TfNSW reference: REN25/00089/002

**SSD-77527735, Mangoplah Battery Energy Storage System, 4178 Holbrook Road, Mangoplah NSW 2652;
Response to Environmental Impact Statement**

Attachment A

OSOM Route Assessment - Port of Melbourne  
 Mangoplah BESS  
 Swept Path Assessment - Rest Area 4

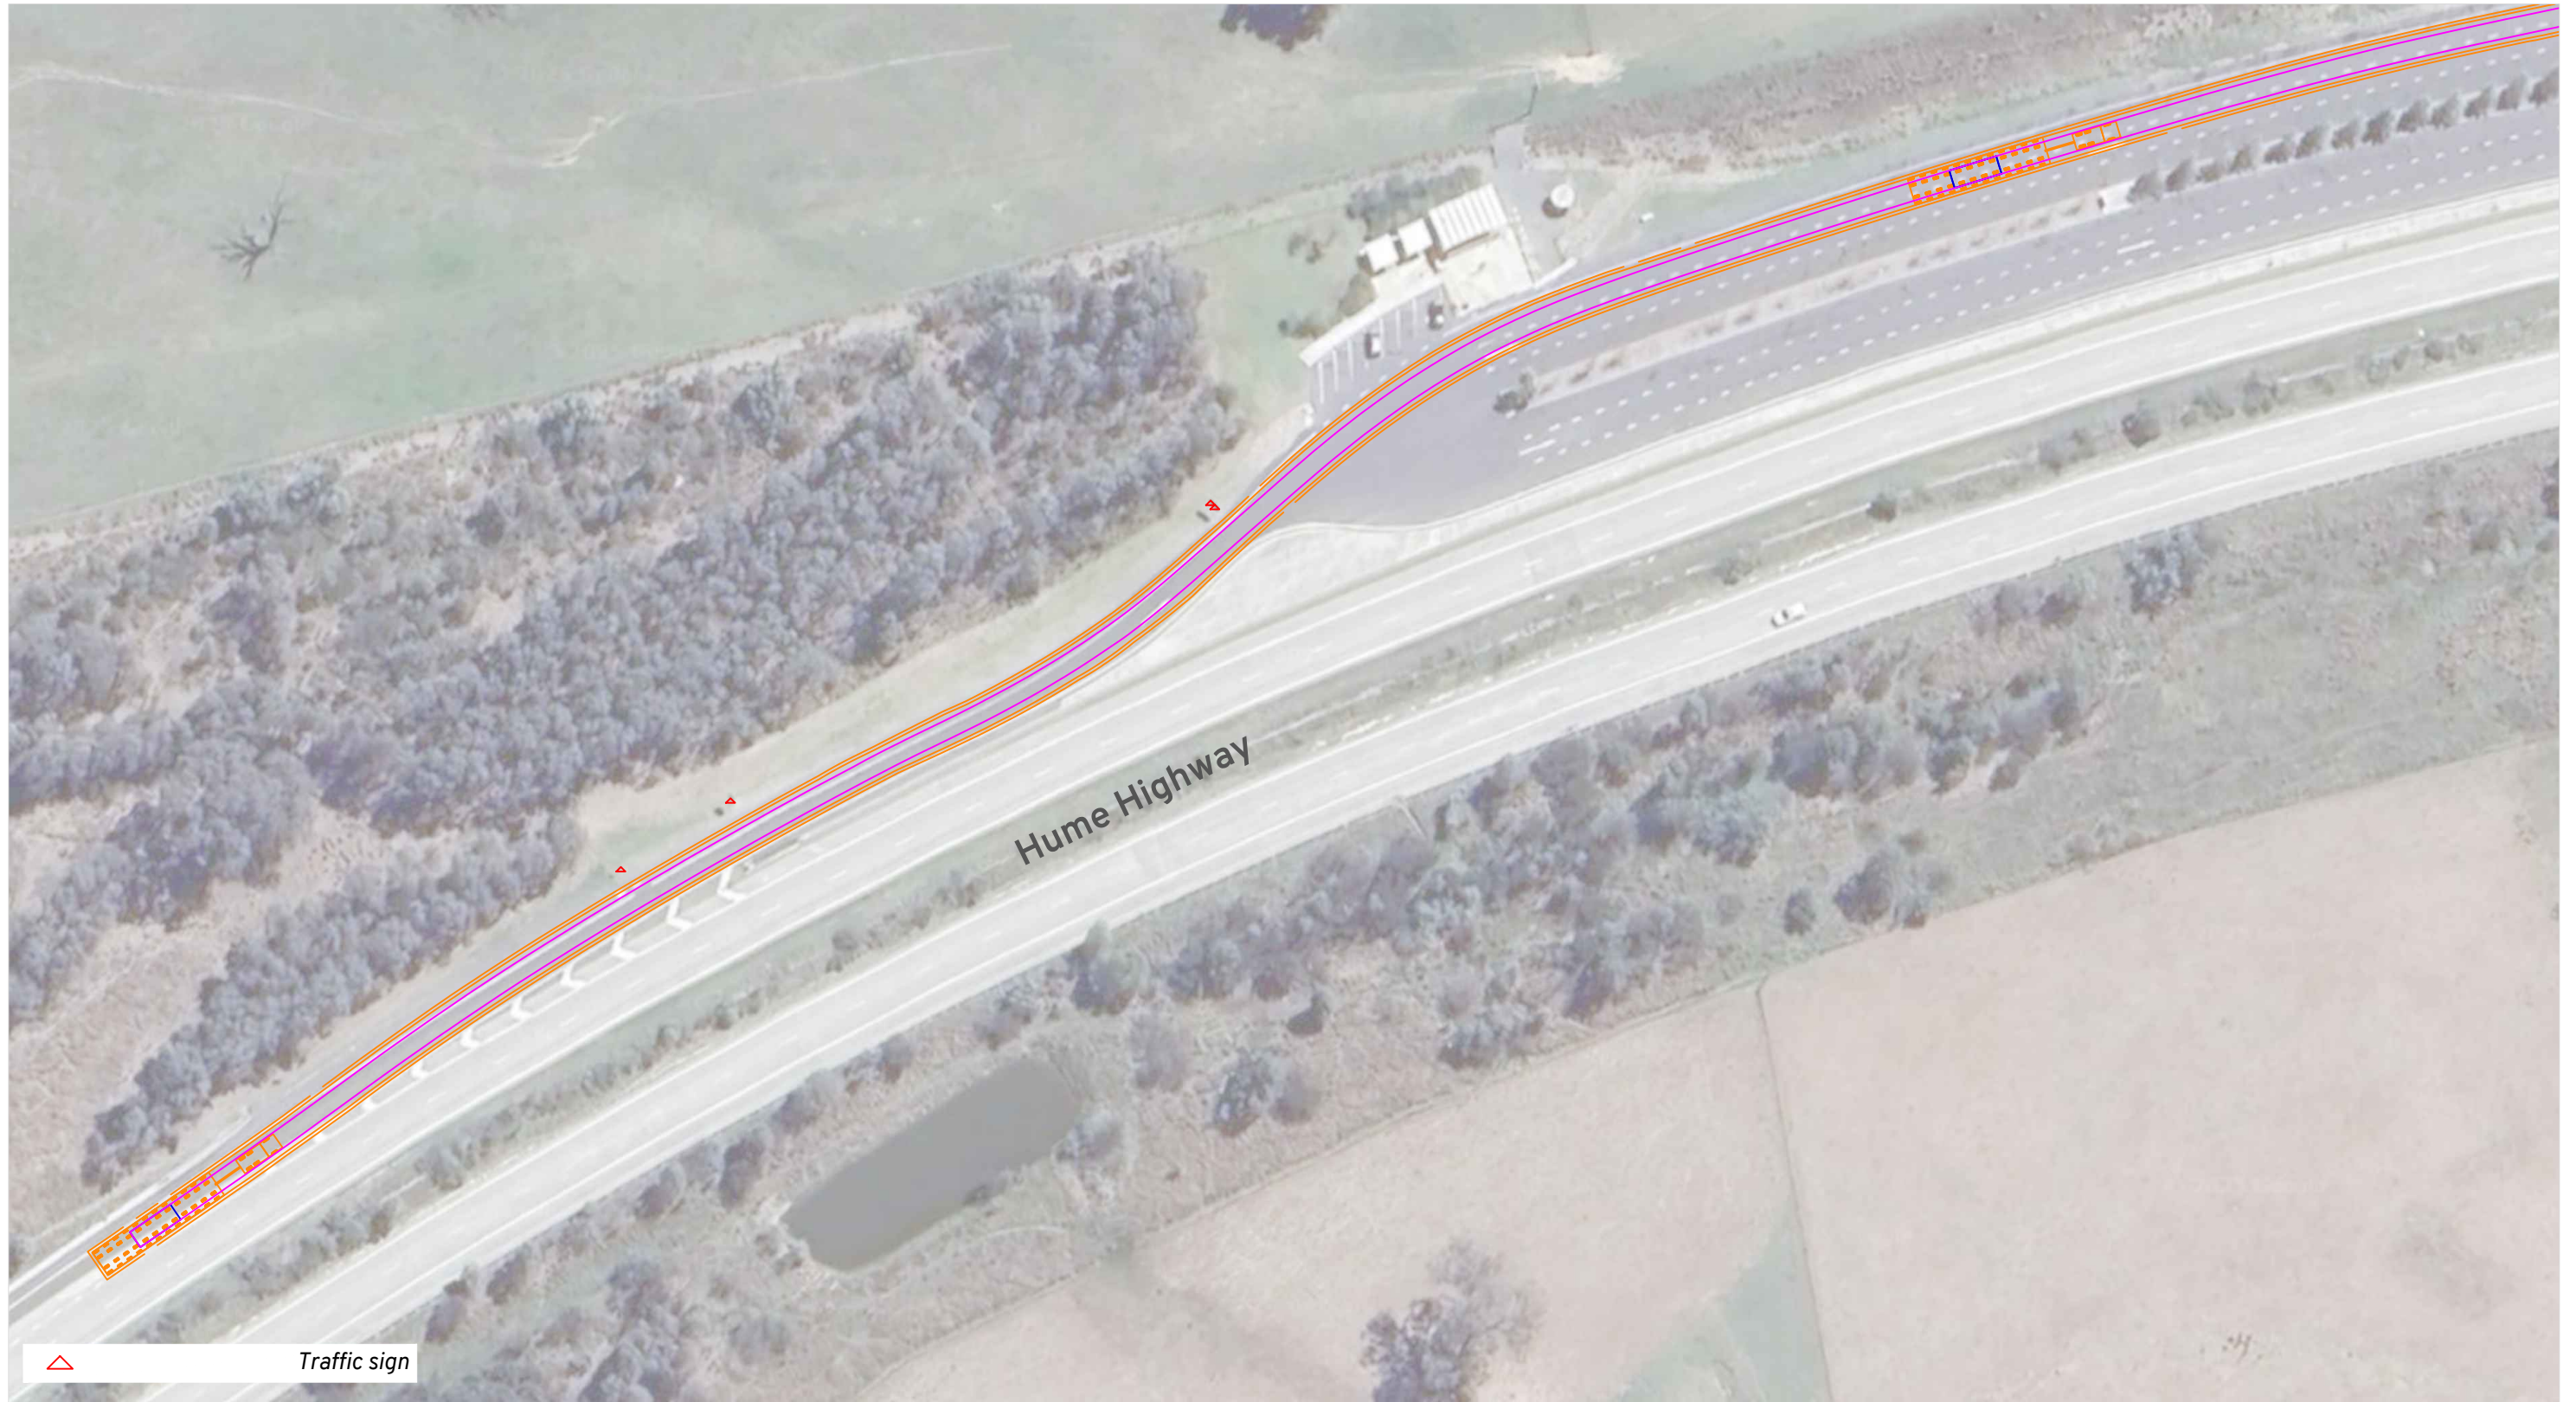
- c. The swept paths provided indicate that the OSOM traverses outside of the marked pavement at Rest Area 5 on the Hume Highway, see Figure 1. Swept paths are to be updated to demonstrate that OSOM movements can occur within the marked roadway, or strategic concept designs are to be provided with road and/or shoulder widening pavement designs. [Strategic-Design-requirements-for-DA-Factsheet.pdf](#)

- d. Consider the level of escort required for the high-risk OSOM. A police escort may be required for high-risk OSOM traversing multiple lanes, as shown in the provided swept paths.

Site Access

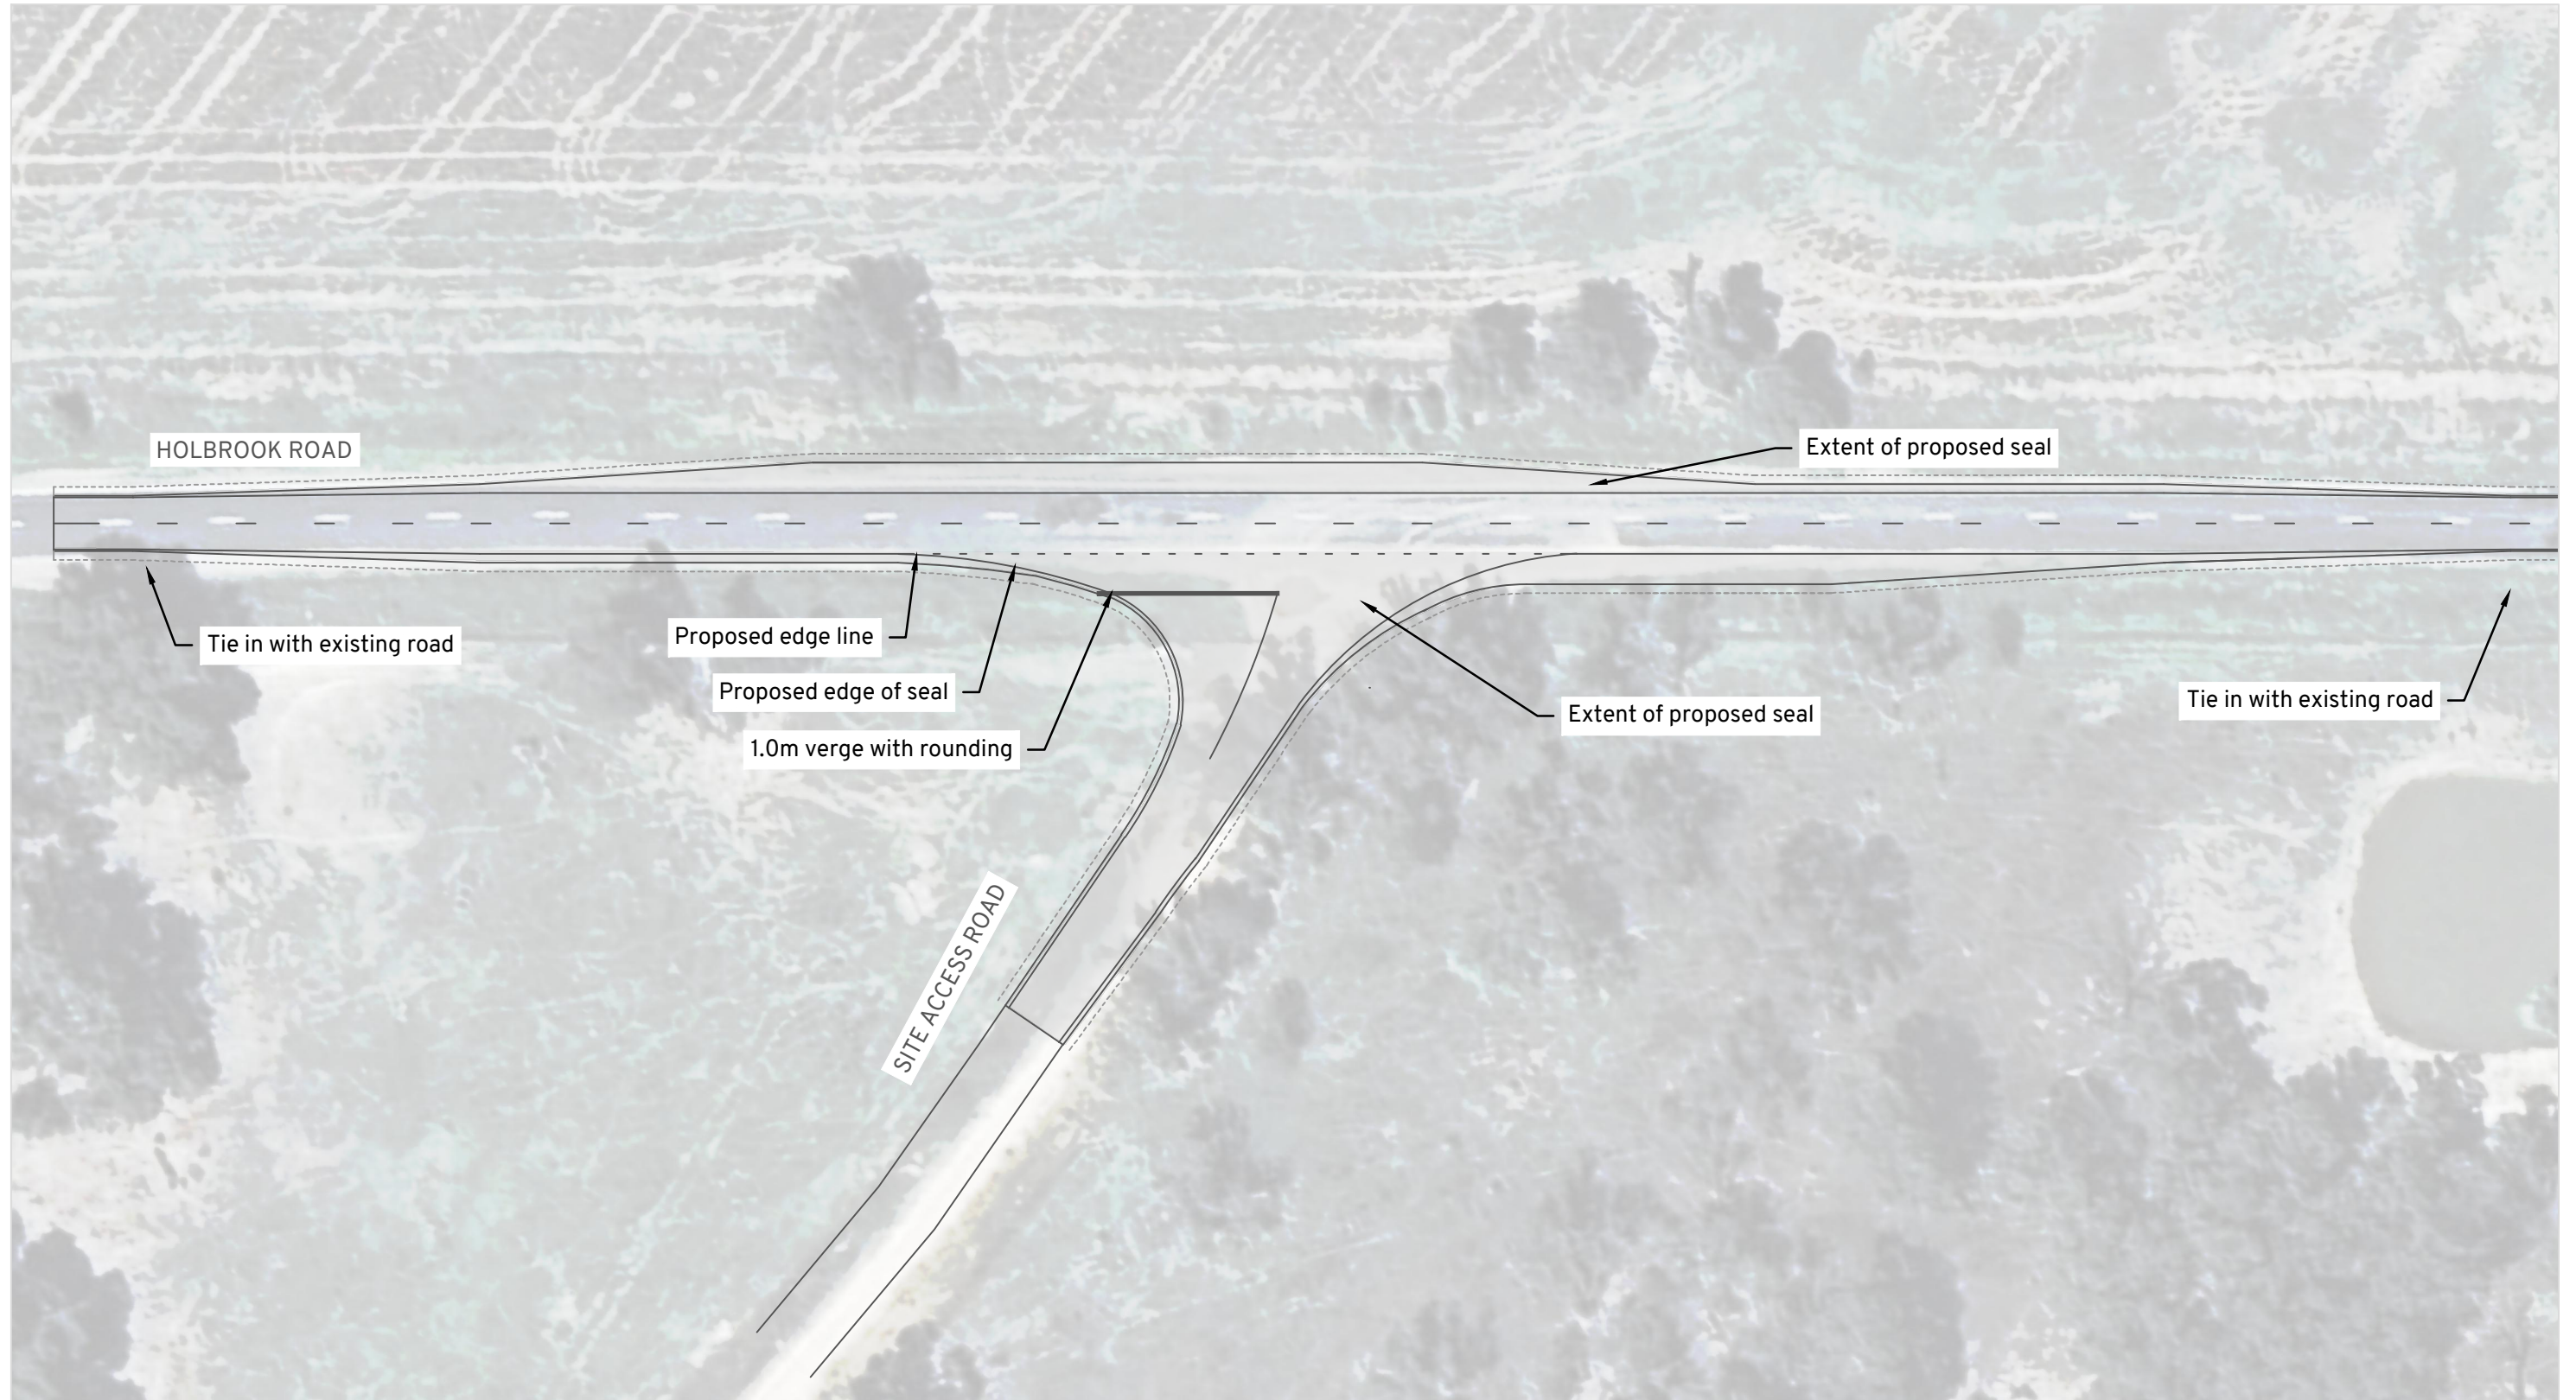
- a. Swept path analysis shows B-double vehicles tracking over the centreline, presenting a potential hazard to vehicles stored at the intersection. Consider revising the intersection geometry and widening.
- b. Consider the reinstatement of existing defined table drains throughout the existing formation.

- c. The typical cross-section proposes a maximum of 4:1 batter slope. TfNSW recommends a 6:1 batter slope, as stated in *Austrroads Guide to Road Design Part 6*, noting that anything steeper than 4:1 is to be protected by a safety barrier.
